REQUEST

The petition proposes to allow the development of the Charlotte Hornets practice facilities and associated accessory uses on a lot that is currently used as surface parking.

Charlotte PEC, LLC

CONTEXT AND PURPOSE STATEMENT

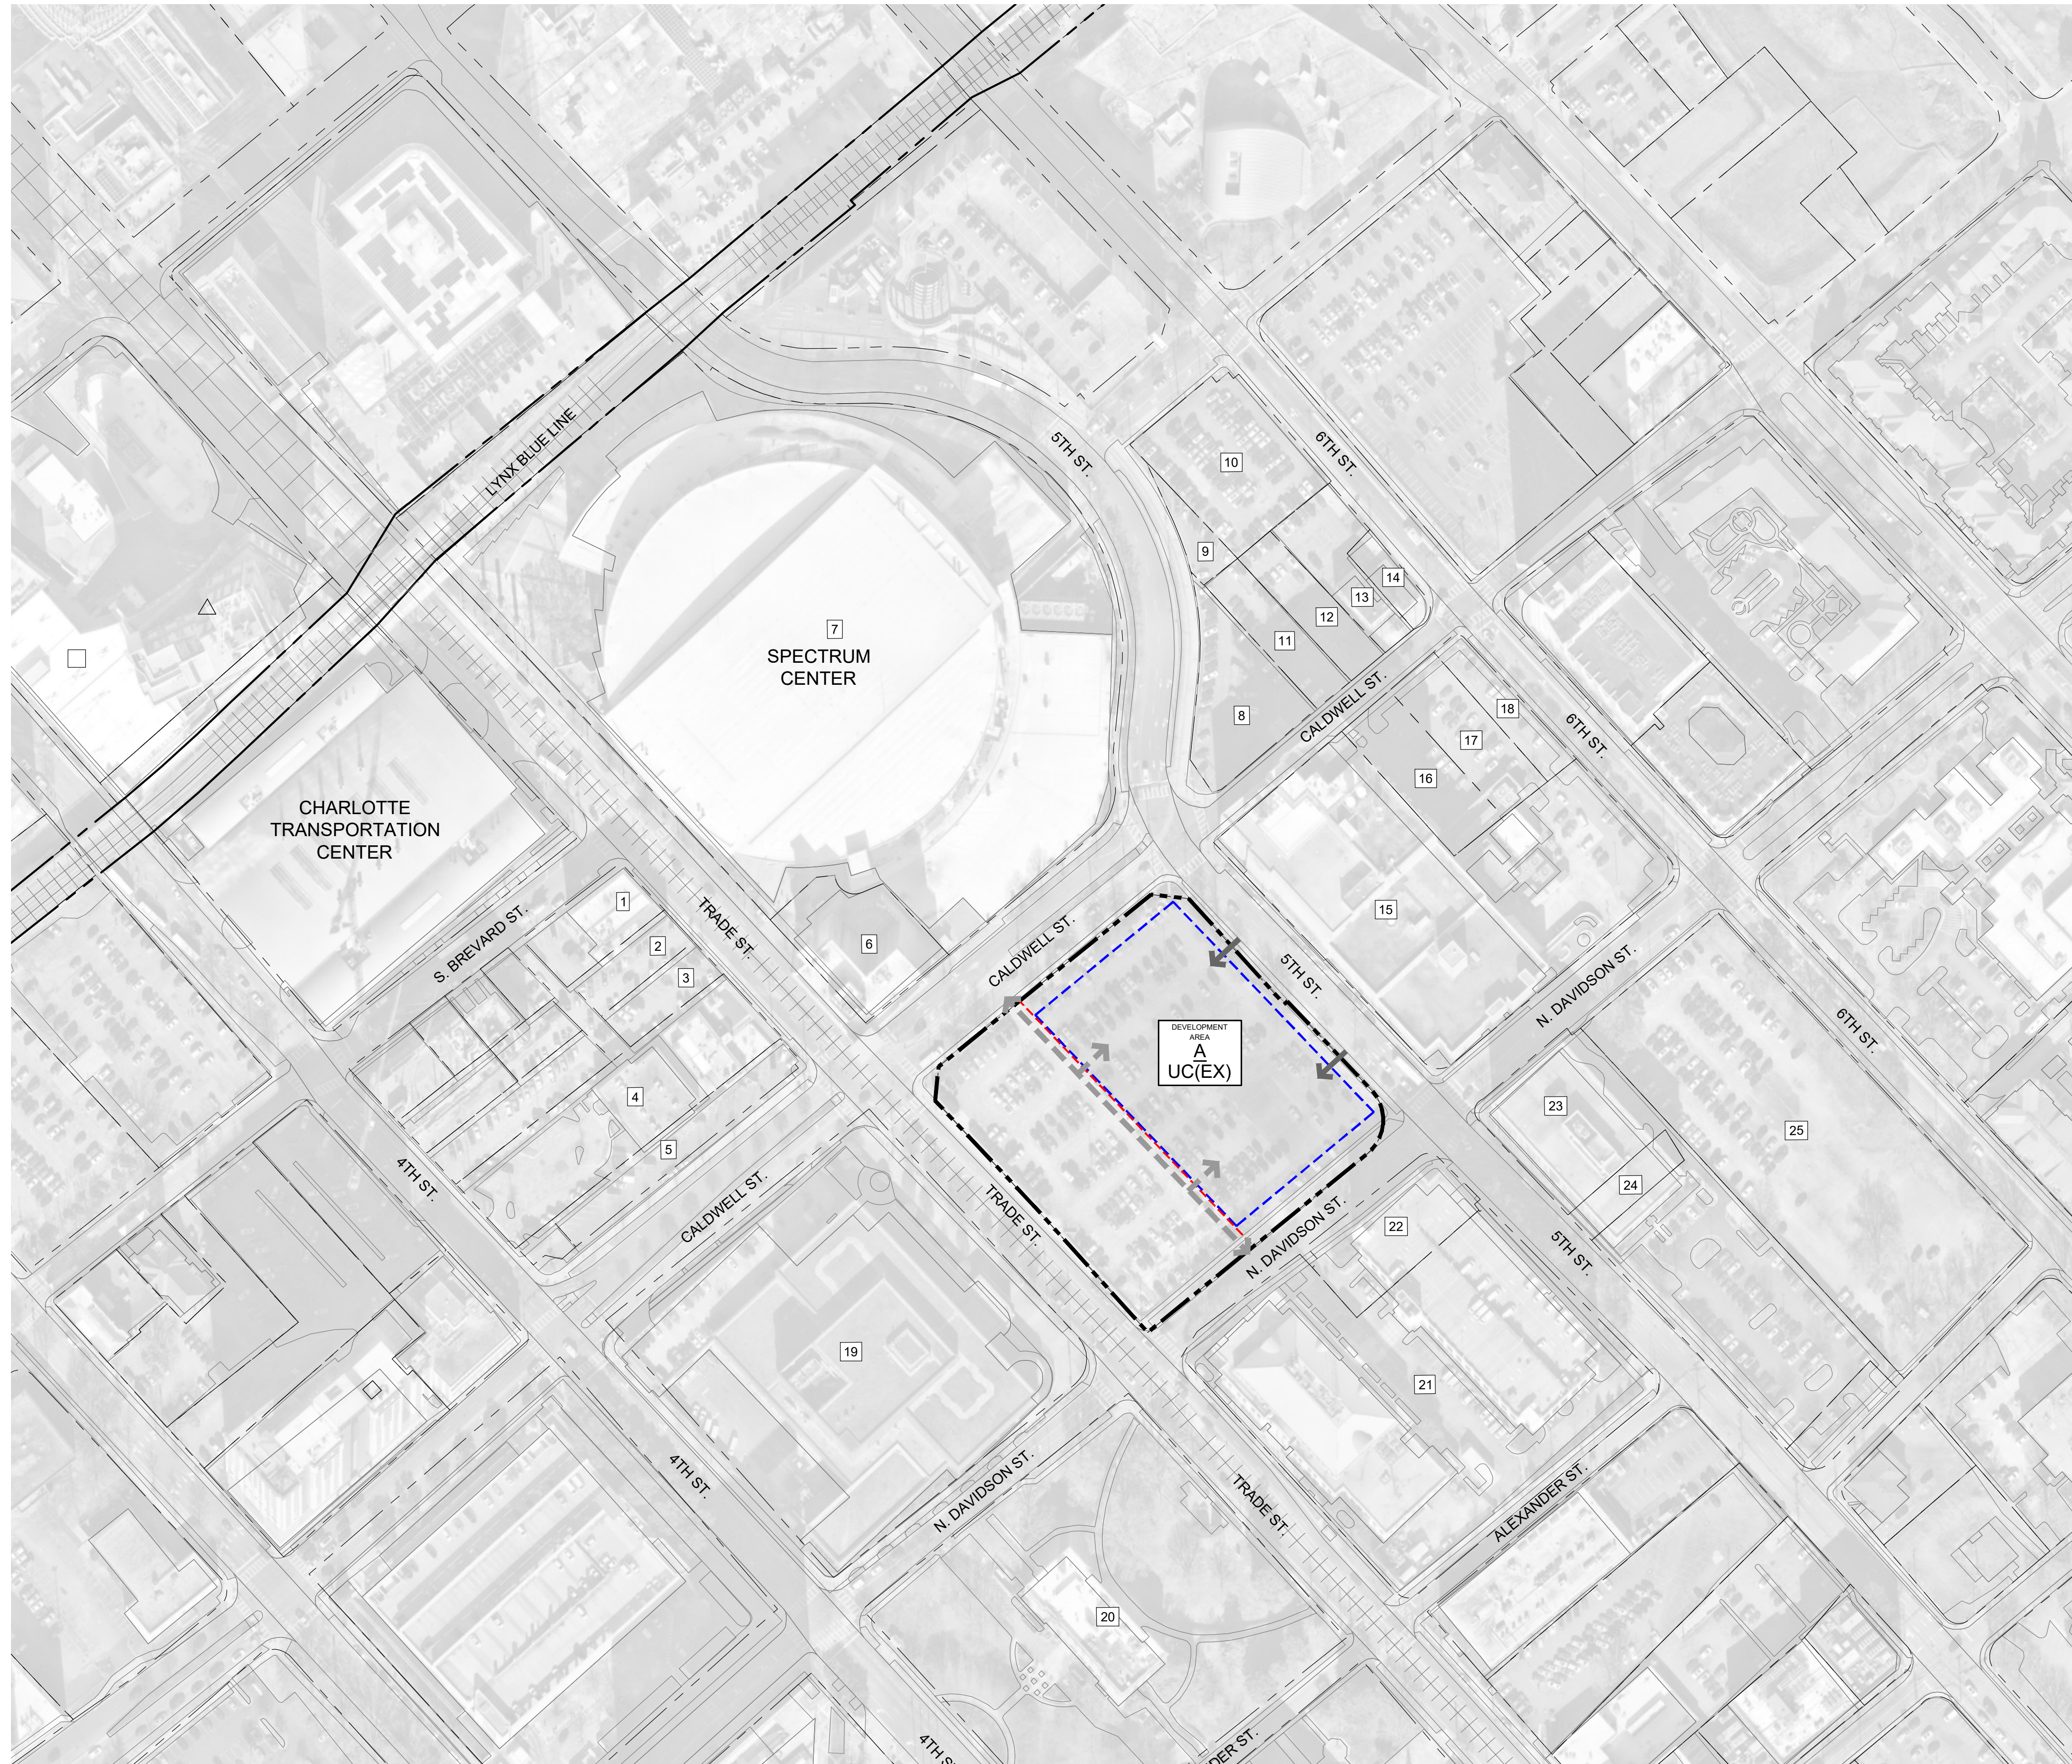
11. In the EX public benefit language regarding the public art feature, add language mirroring the note in section 6 stating that if the art were to be covered by new development then the art feature would be replaced elsewhere on the site to satisfy the EX public benefit requirement.

**SCHEMATIC SITE PLAN**

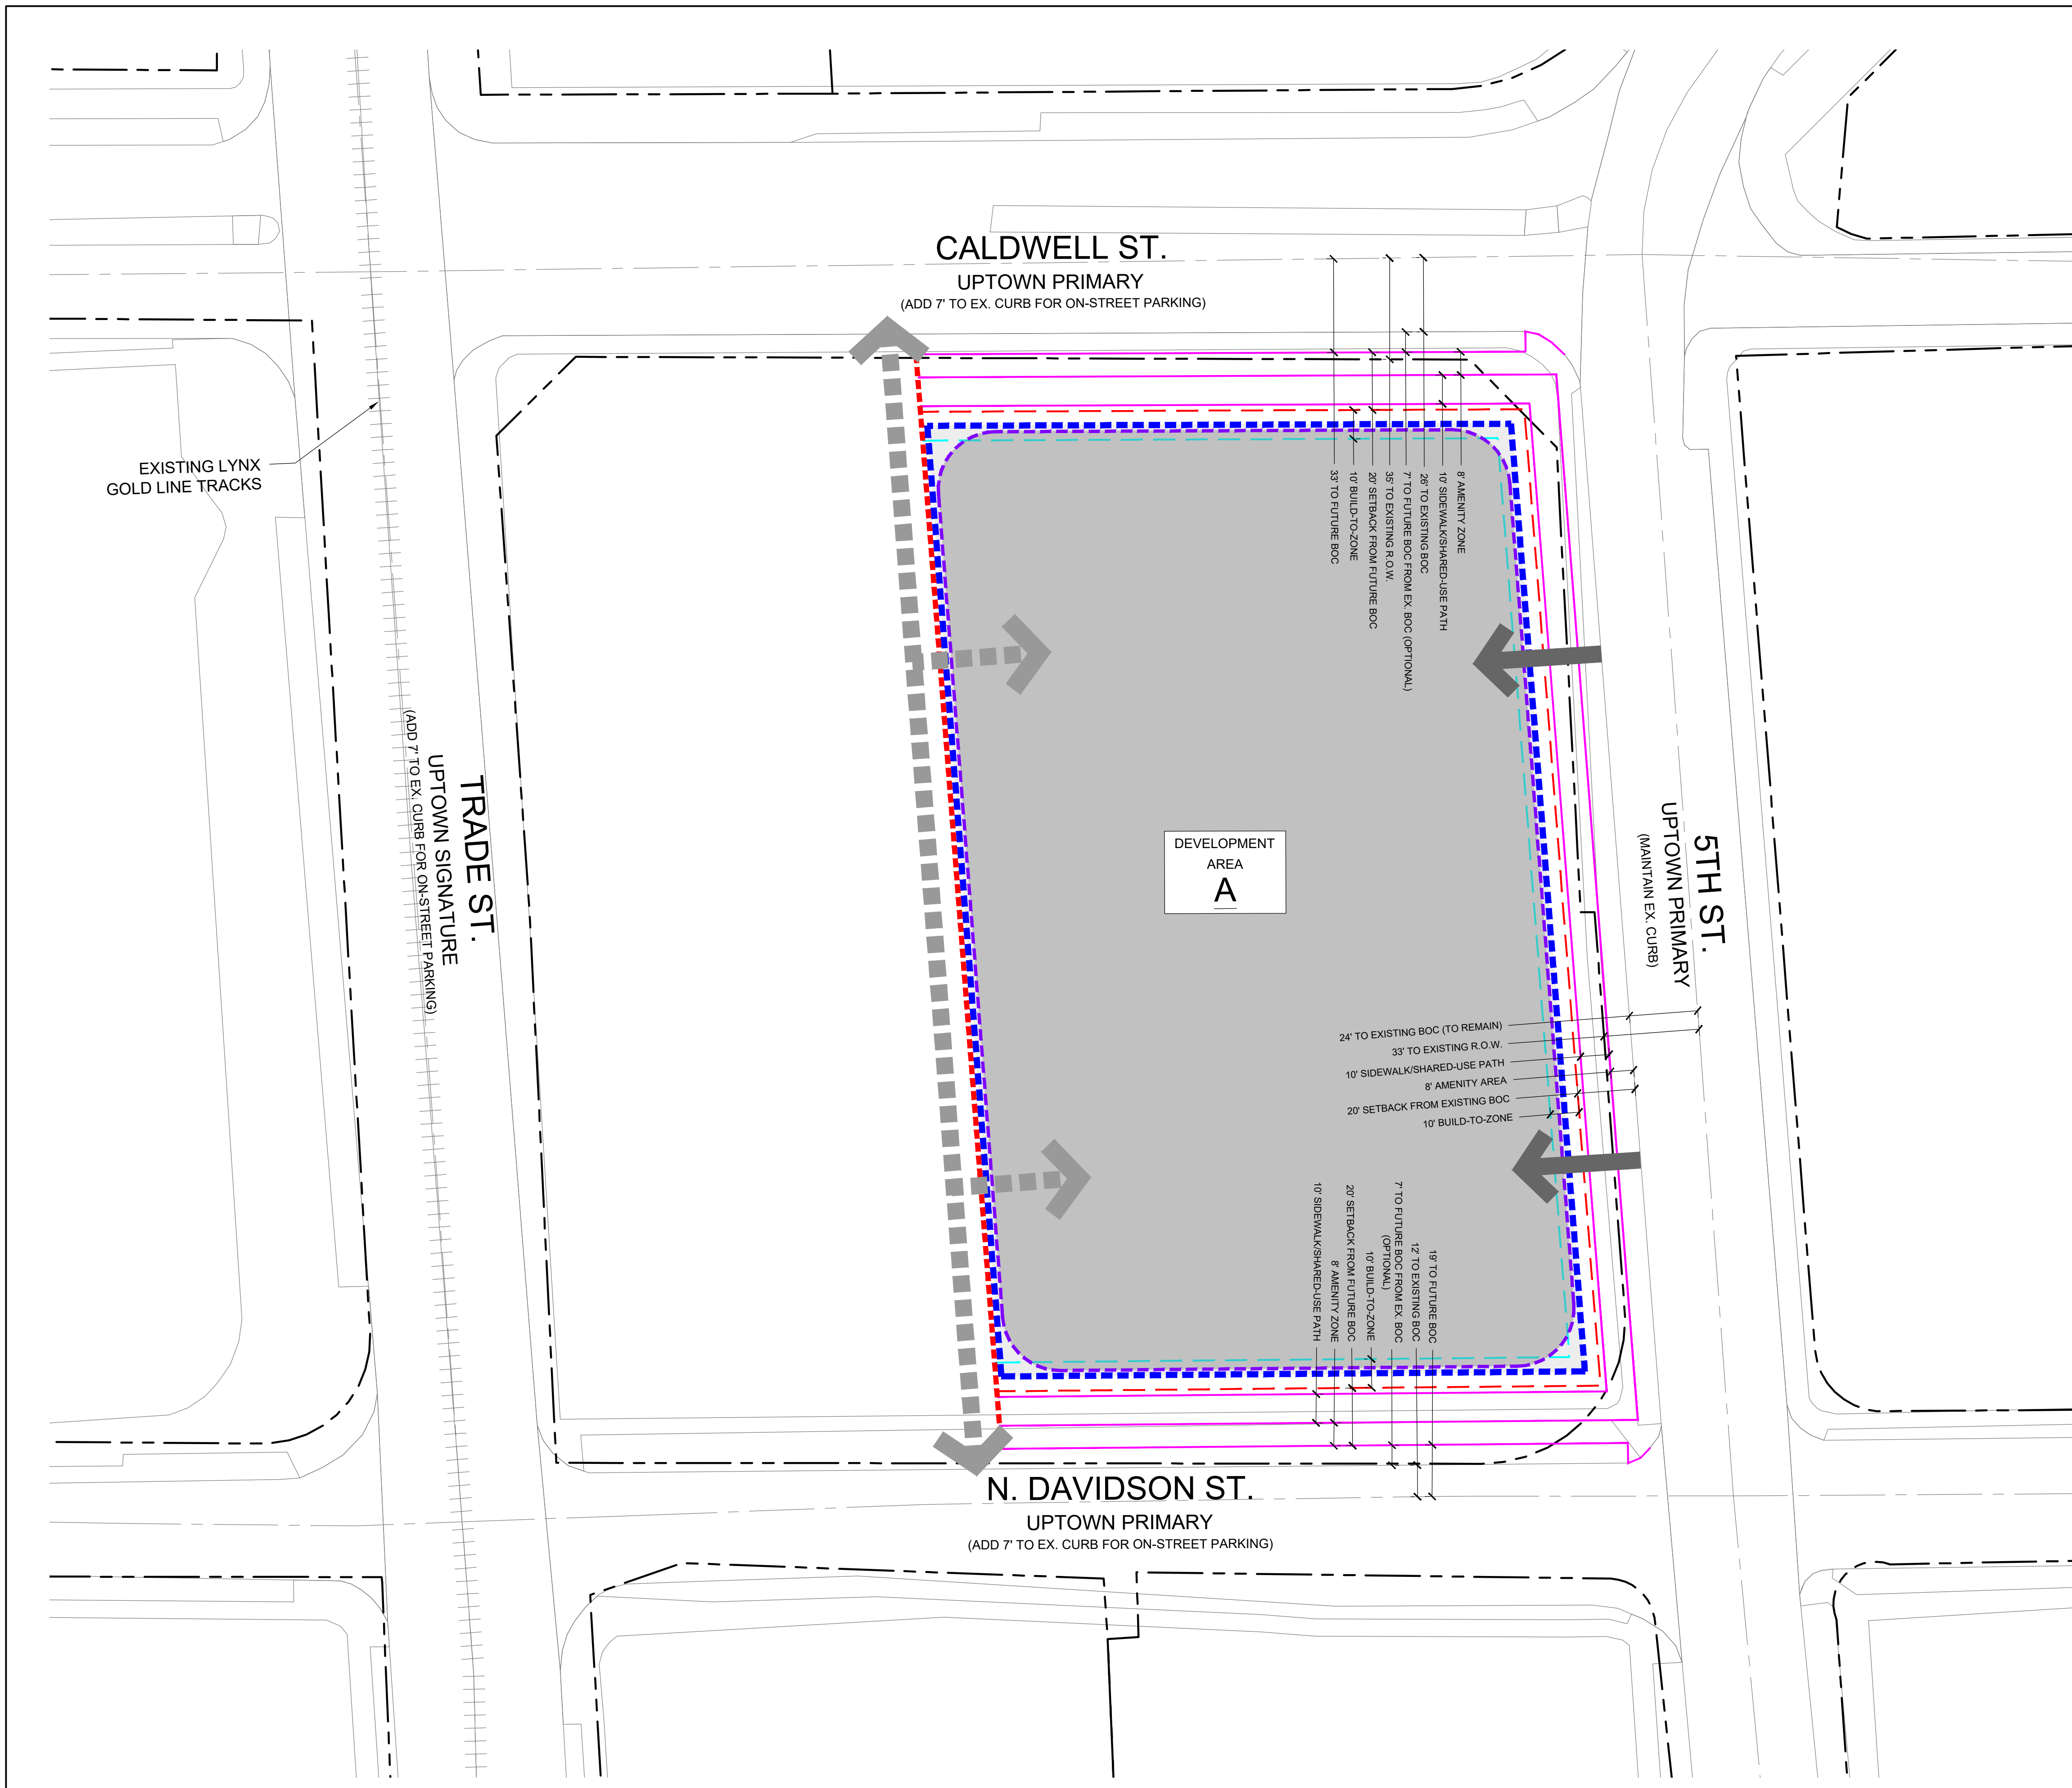
4. ~~Revise the site plan and conditional notes to have the sidewalk alignment be consistent across the site's entire N. Davidson Street frontage.~~ **Addressed**

8. ~~State the purpose of the limited access driveway in the conditional notes.~~ **Addressed**
